Lime Down

Solar Park

**Statement of Common
Ground with Cotswolds
National Landscape Board**

Document Reference: EXAM/8.7

Title:
Figure 4-4: Main Infrastructure Layout Changes between PEIR and DCO Application

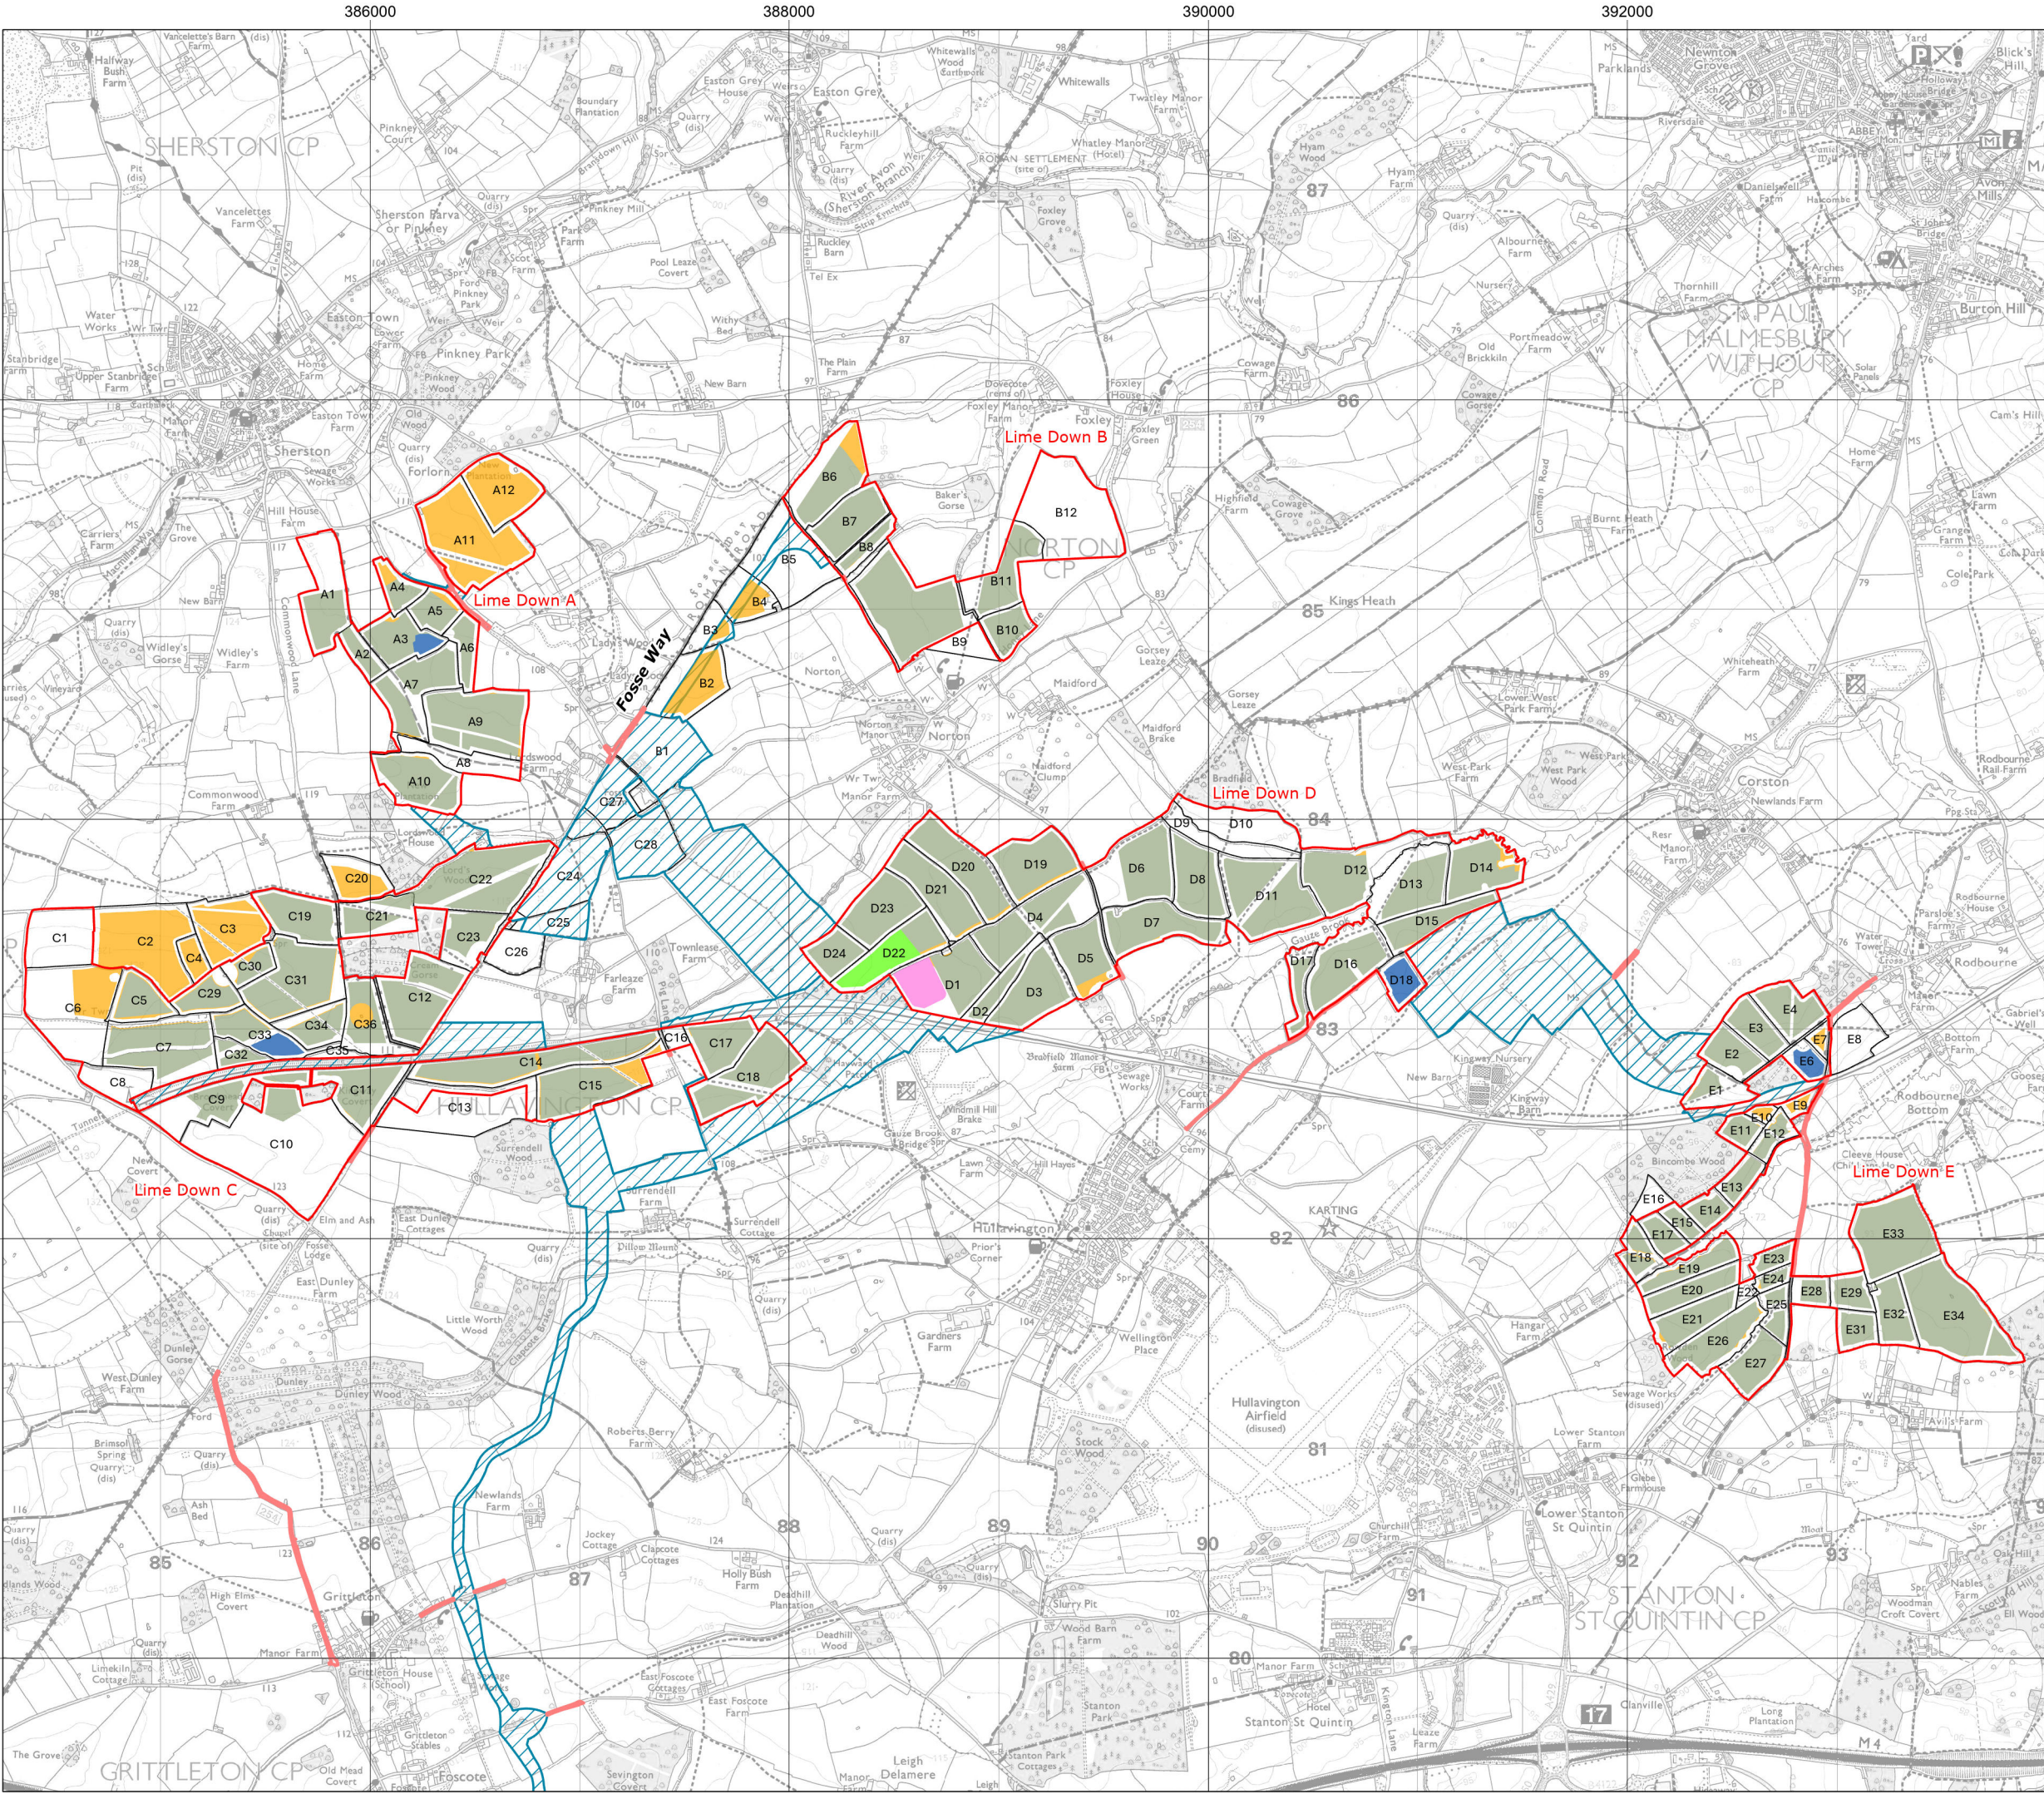
| Reference | Sub-topic | CNLB Position | Applicant's Position | Status |
|-----------|---|---|---|-------------------------|
| 3.1.16 | Removal of Solar PV Panels from Fields A11, A12, C2, C3 and C4 (PMIE 2) | The CNLB note and support the decision to remove Solar PV Sites from Fields A11, A12, C2, C3 and C4, to avoid significant adverse landscape and visual effects on the CNL and its setting. | The final iteration of the Scheme avoids panels in Fields A11, A12, C2, C3 and C4. These have been removed from the Scheme, to avoid significant adverse landscape and visual effects on the CNL and its setting. This was confirmed in a meeting with the CNL Board on 30th March 2026, it was confirmed that this relates to PMIE 2. PMIE 2 is now resolved. | Agreed |
| 3.1.17 | Removal of Solar PV Panels in the southern part of Field A1, the remainder of Field C6 and Fields C7 and C9 (PMIE 6). | CNLB support the decision to remove Solar PV Panels in the southern part of Field A1, the remainder of Field C6 and Fields C7. CNLB note that Field C9 remains unchanged from the design shown at statutory consultation (see PMIE 6). | The final iteration of the Scheme includes the avoidance of panels in the southern part of Field A1, the remainder of Field C6 and Fields C7. These areas are identified for habitat enhancement. Following a meeting with an officer from the CNL Board on 30th March 2026, it was confirmed that this relates to PMIE 3. Discussions are ongoing surrounding panels in C9. | Under Discussion |

Title:
Figure 15-2: Construction Vehicle Emissions
Assessment Road Network

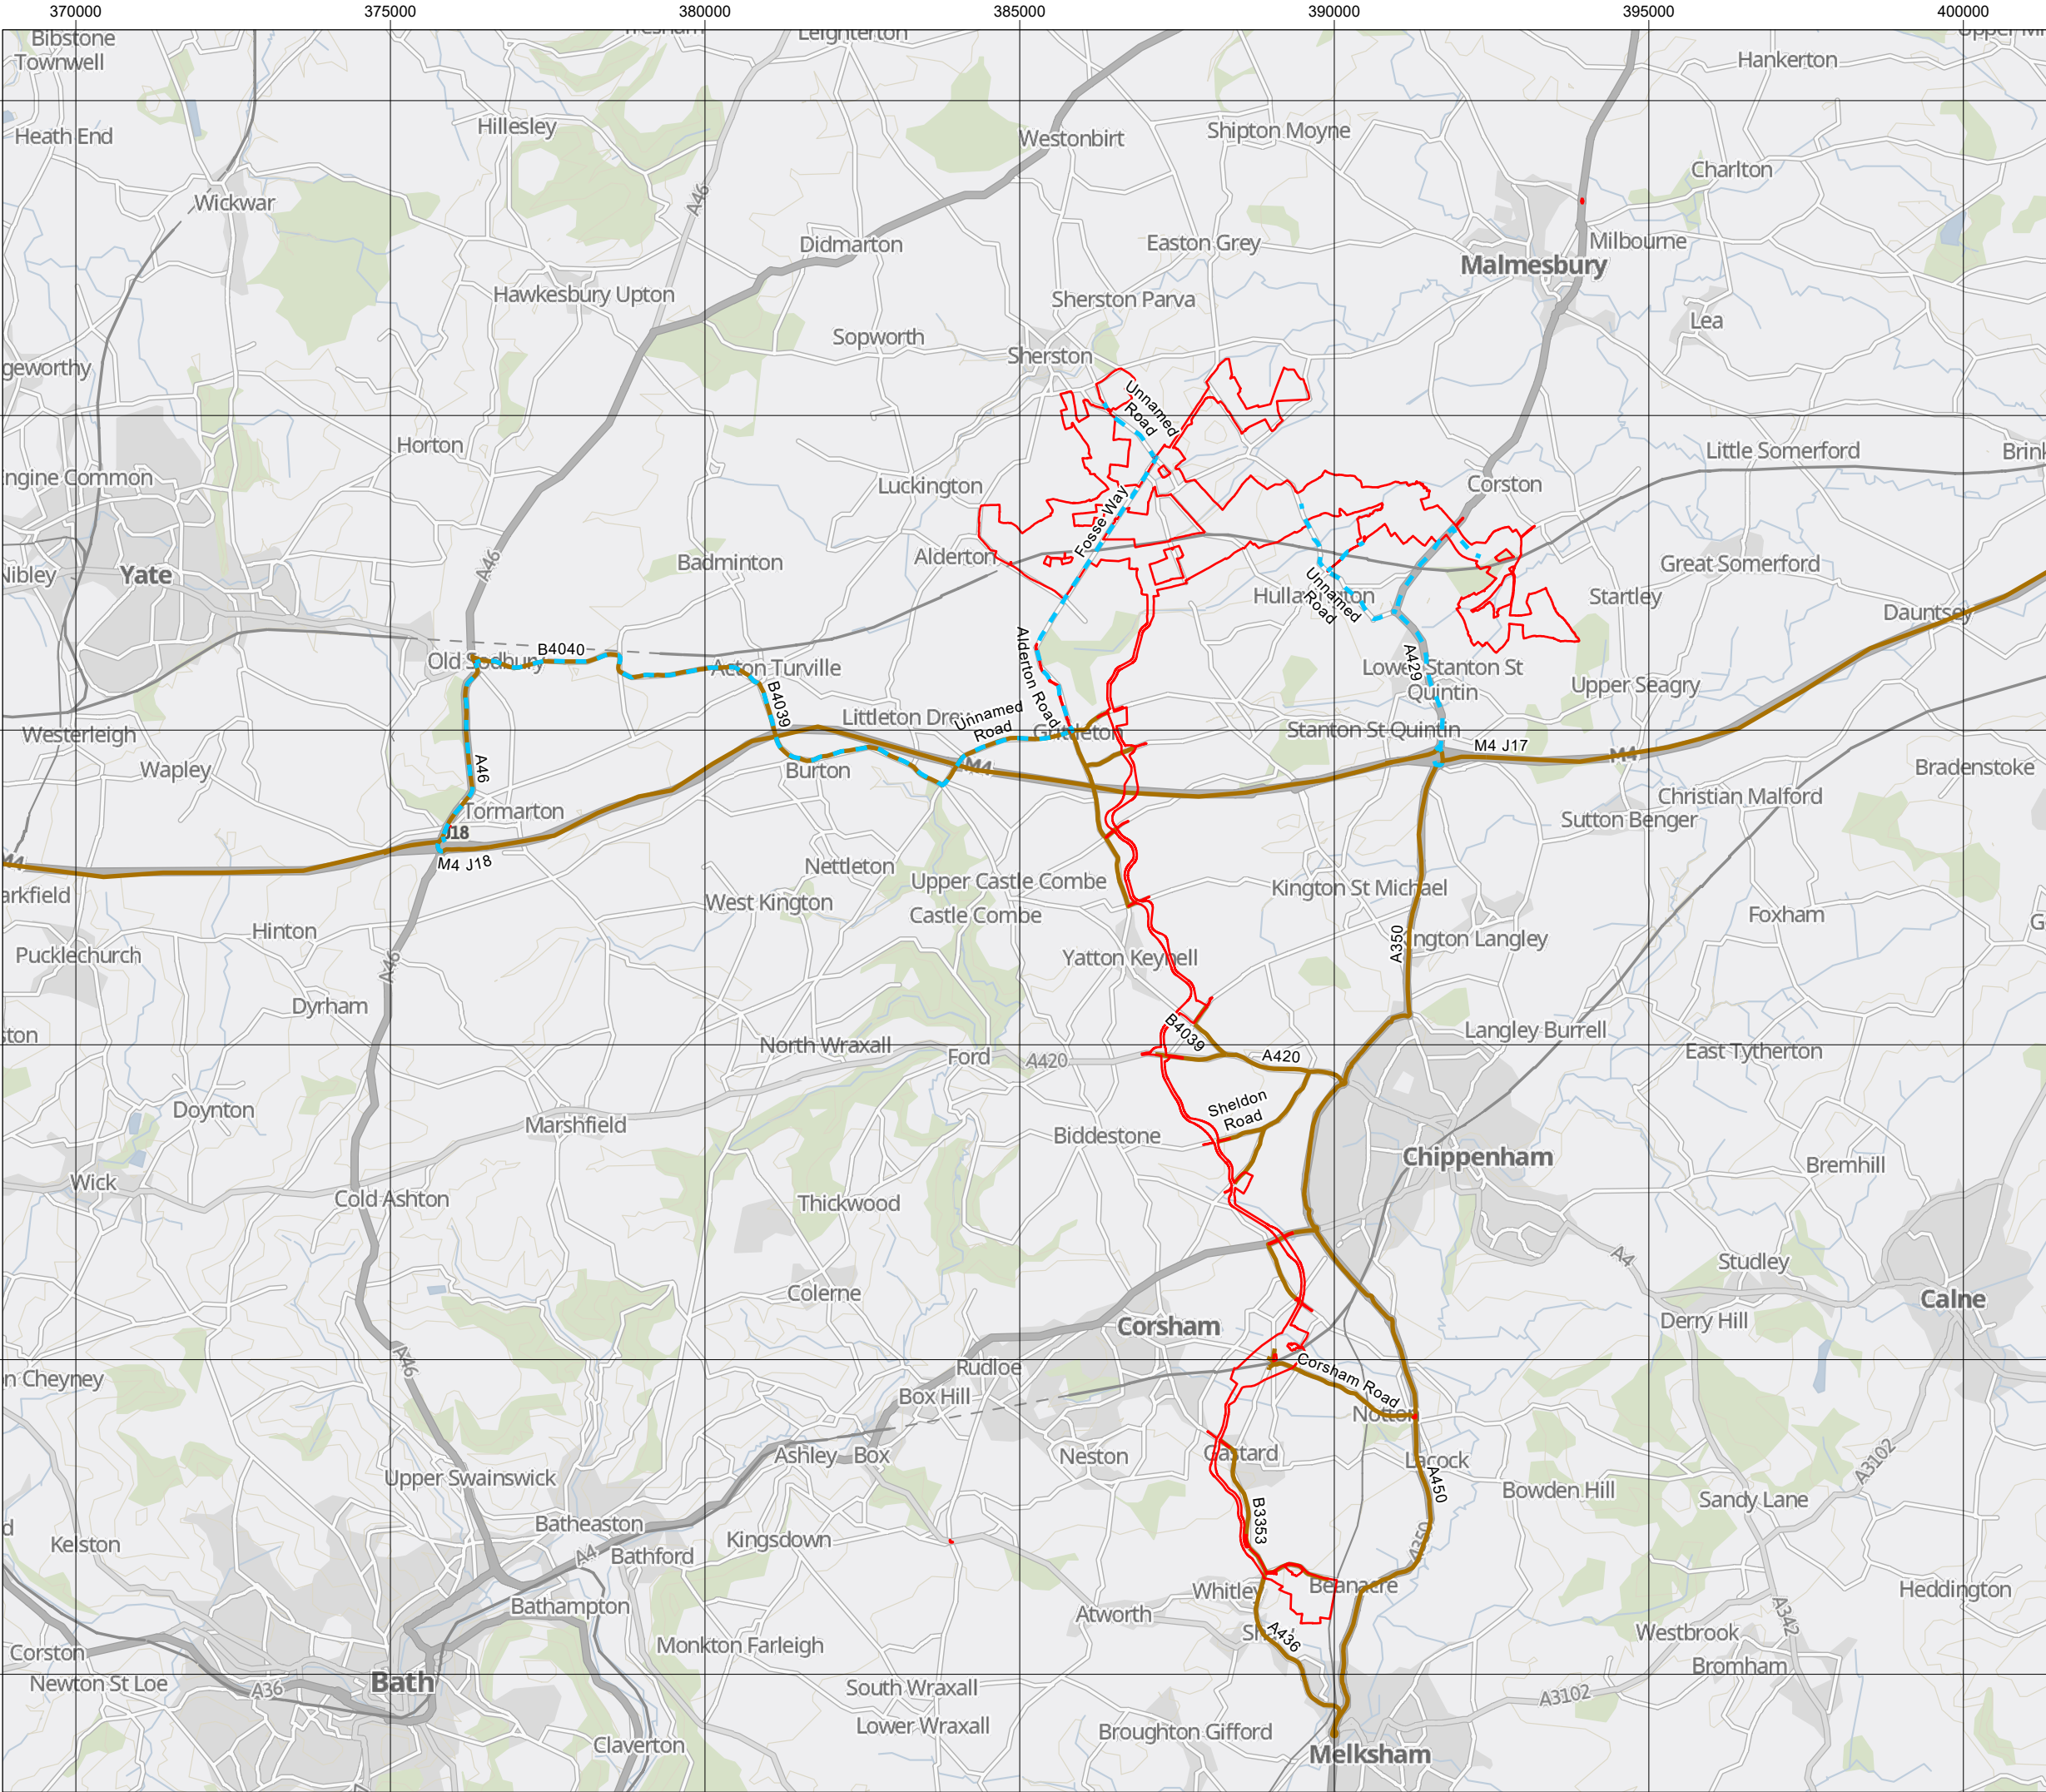
| Reference | Sub-topic | CNLB Position | Applicant's Position | Status |
|-----------|-----------|--|----------------------|--------|
| | | <p>Cotswolds National Landscape. This would apply to traffic movements on roads along the CNL boundary as well as to traffic movements on roads within the CNL.</p> <p>Figure 13.1 of the ES shows a proposed construction traffic route to serve Sites A, B and C which runs from M4 J18 through the CNL along the A46, B4040, B4039, an unnamed road east to Grittleton and then the Alderton Road and Fosse Way, leaving the CNL at the crossroads with Fosse Lodge. The route then continues outside of the CNL up the Fosse Way.</p> <p>Table 13-24 identifies that overall traffic flows along the B4040, the unnamed road west of Grittleton, Alderton Road and Fosse Way all within the CNL would exceed the 10% threshold in terms of total traffic. Increases in HGV flows along these roads would also exceed the 10% threshold along these routes as well as along the B4039. HGV flows would increase by between 68.5% and 250% on these routes and</p> | | |
